Portland Water District

November 29, 2018

Re: 22 Bramhall Street, PO
Ability to Serve with PWD Water

12/17/2018
C11-01

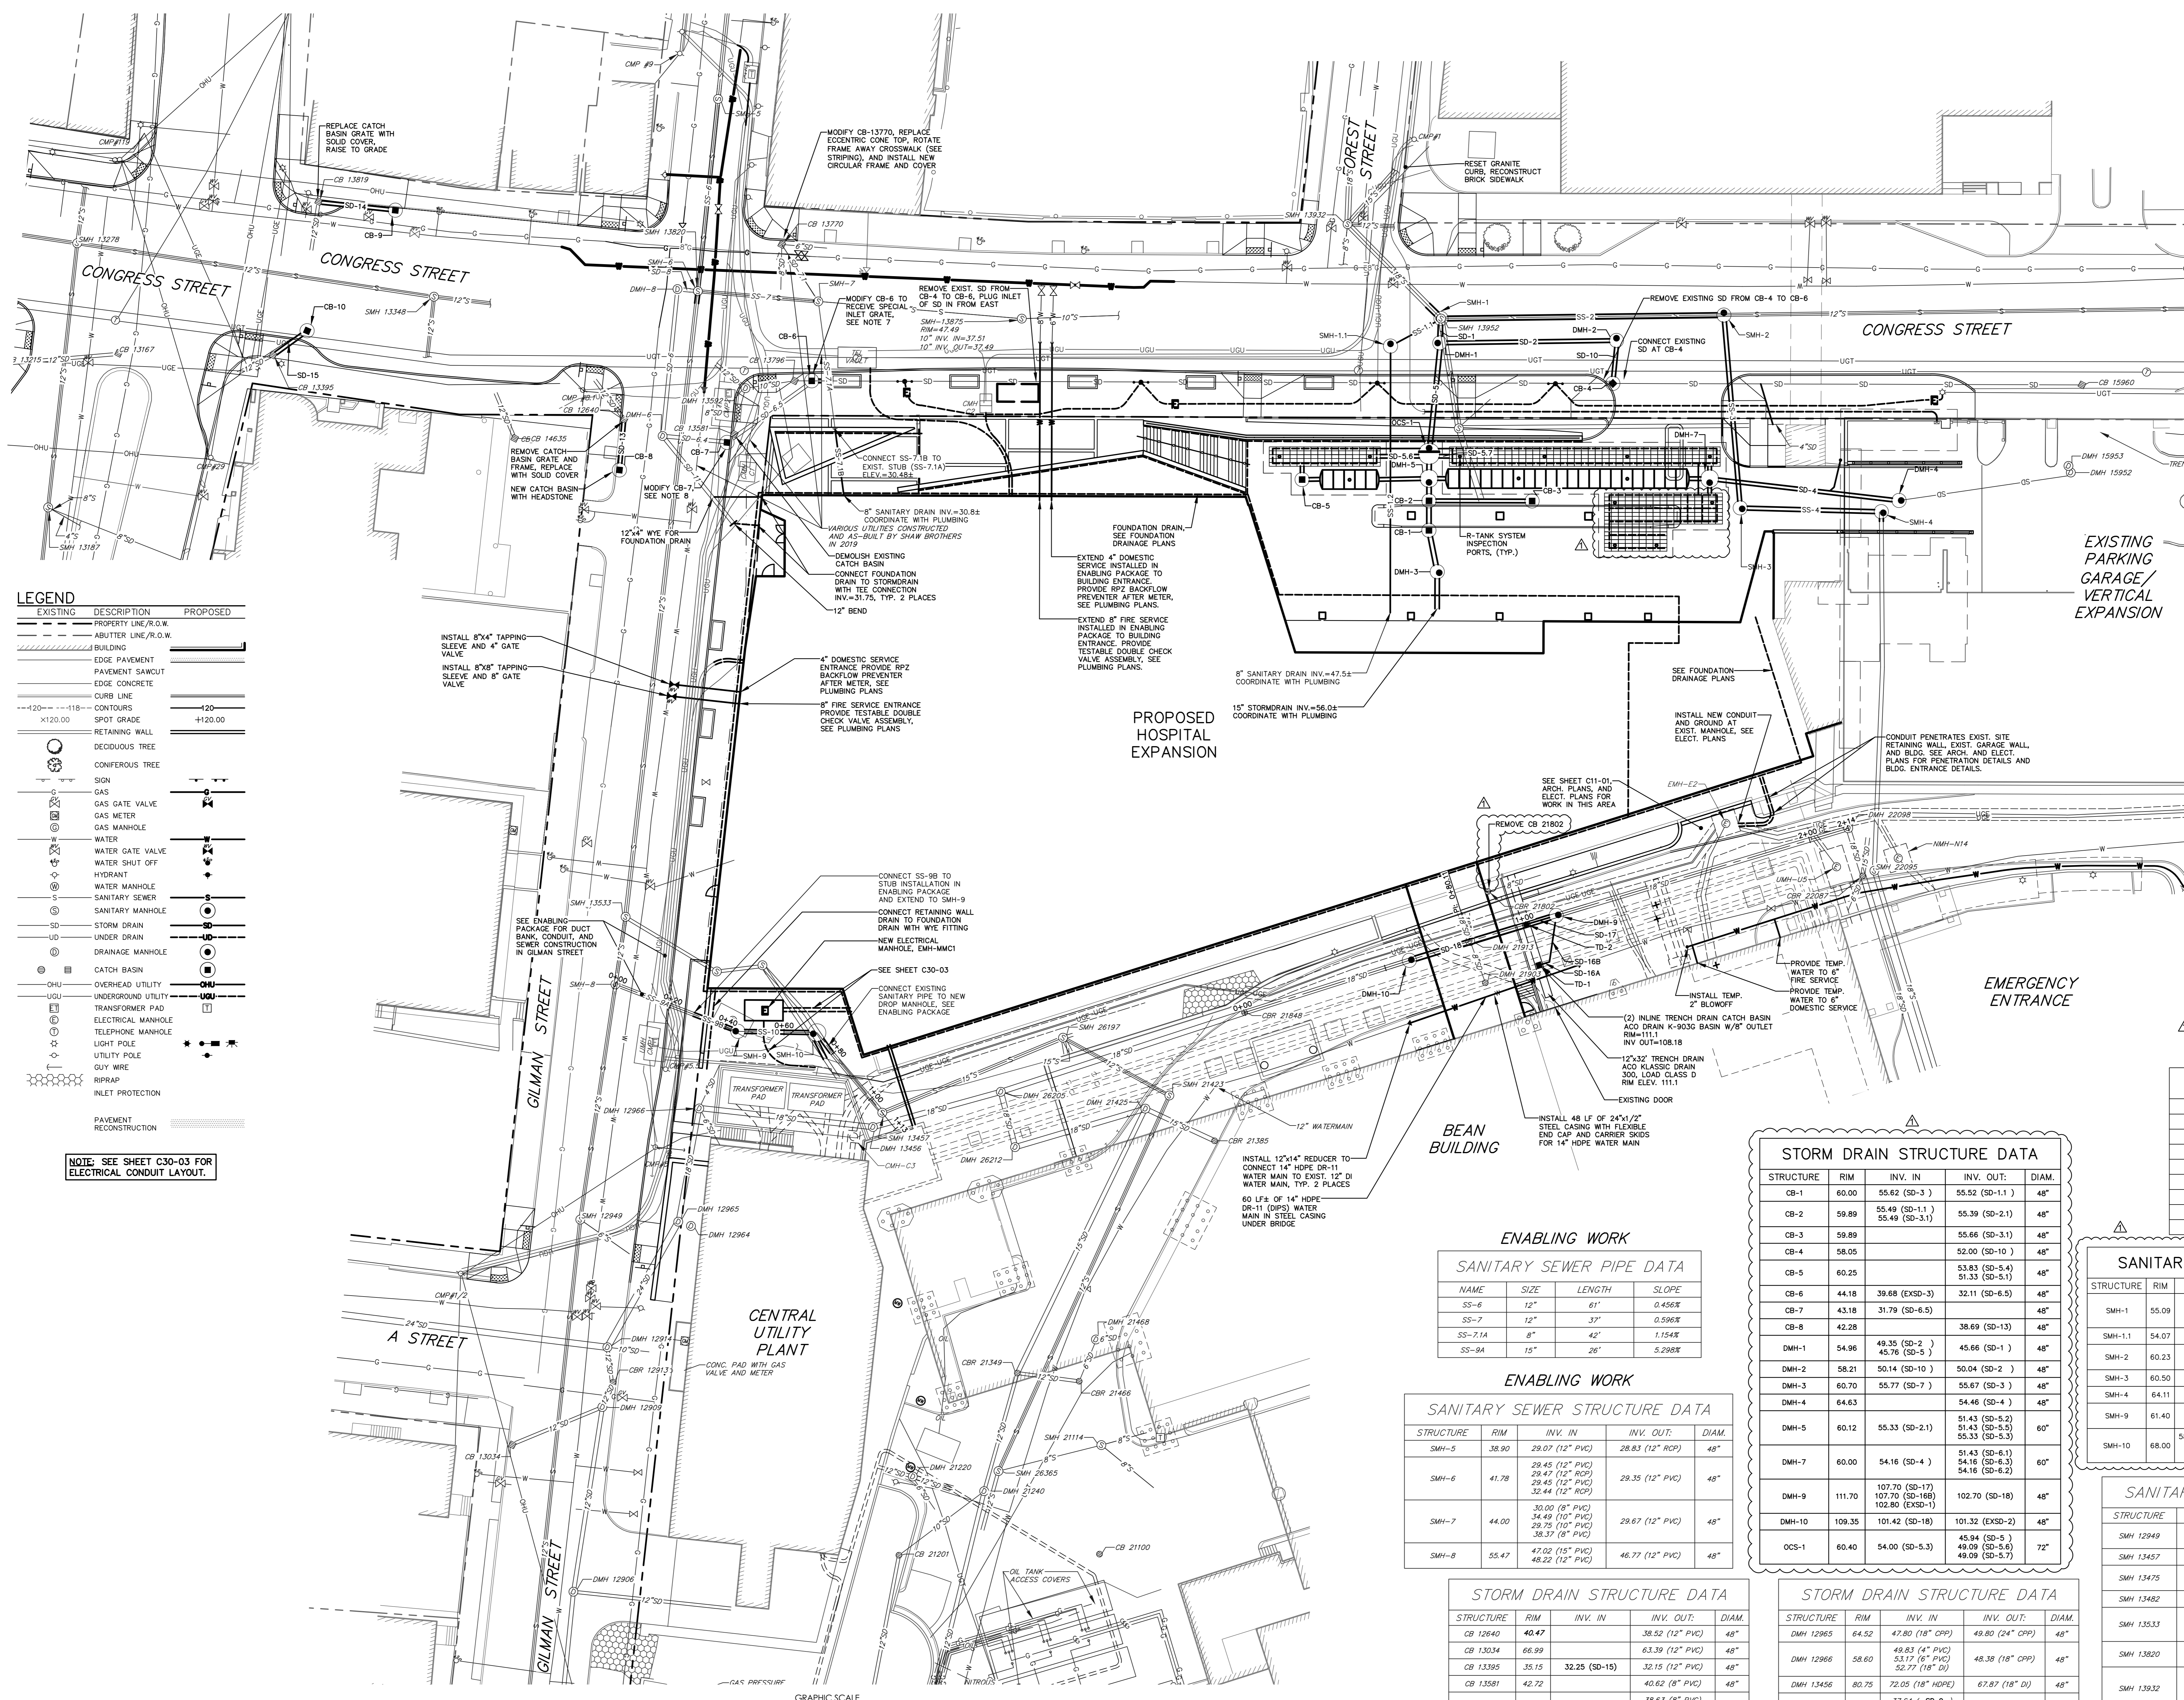
- A new 8-inch fire service and 4-inch domestic water service may be installed from the water main in Congress Street. The service(s) should enter through the properties frontage on Congress Street at least 10-feet from any side property lines. The service(s) are approved based on connection to a renewed water main in Congress Street that is of sufficient size to supply water to the site. The existing 6" CI water main in Congress Street is insufficient to provide water to the site.

- A new 8-inch fire service and 4-inch domestic water service may be installed from the water main in Gilman Street. The service(s) should enter through the properties frontage on Gilman at least 10-feet from any side property lines.

- The existing site is currently served with a 1-inch domestic water service and a 6-inch fire service; the size of these services is undersized for the proposed use. These service must be retired per PWD standards, which includes shutting the corporation valve and cutting the pipe from the water main for the 1-inch service, and removing the valve and capping the tee for the 6-inch service.

- An approved backflow prevention device must be installed on the service line directly after the meter prior to service activation. Please refer to the PWD website for more information on cross-connection control policies.
